Stewart Patrick Esq.
Hailwood House,
Park Avenue,
Wortley, S35 7DR.

April 13th 2021.

Trees and your planning application.

SITE PLAN

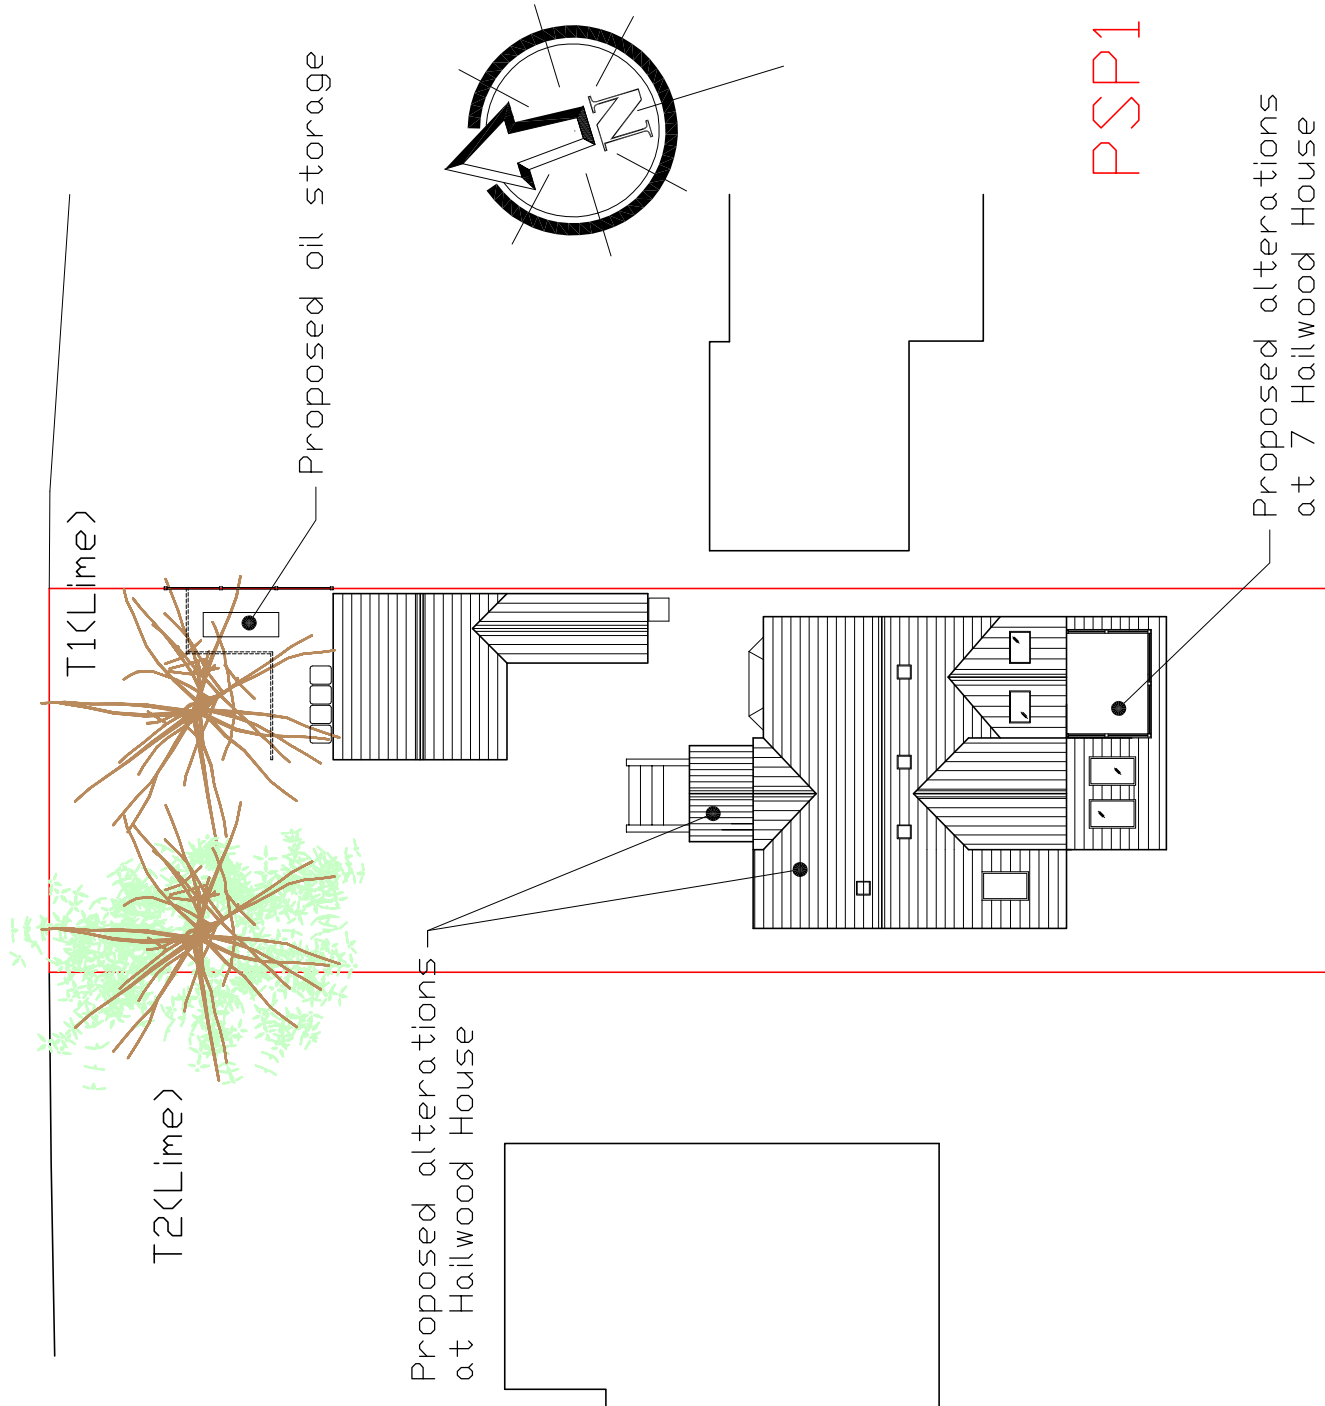
Both trees are approximately 20 metres tall. Both are in reasonable condition and appear to be fairly typical of Common Lime trees grown in these situations. The trees are part of a uniform row of trees that extends alongside the road. Your driveway runs between the two trees. Your designer has marked the trees on the site plans, T1 is to the east of the driveway, T2 is to the west. T1 is 700 mm diameter and T2 is 750 mm.

This oil tank is going to be quite close to tree 1. Fortunately, it is feasible to construct a concrete stand without doing any excavations, so damaging the roots of tree 1 is not necessary.

According to *British Standard 5837 2012 Trees in relation to design demolition and construction – Recommendations* a tree the size of tree 1 would have a root protection area of 222 square metres (a circle, tree at the centre, of radius 8.4 metres) so the loss of 7 square metres is insignificant.

3. The proposals in the tree protection method statement should be followed.
4. The stand for the heating oil tank should be constructed using a no-dig system of surfacing, probably similar to the one illustrated in photo 7.
5. I consider the two Lime trees to be overdue for pruning. I suggest they are pruned with the objective of reducing their height considerably, and then managing them in the future to not allow them to get quite so tall. If you could persuade the neighbours to prune their trees similarly, I think this would be welcomed by the Tree Officer and the neighbourhood's landscape would benefit.
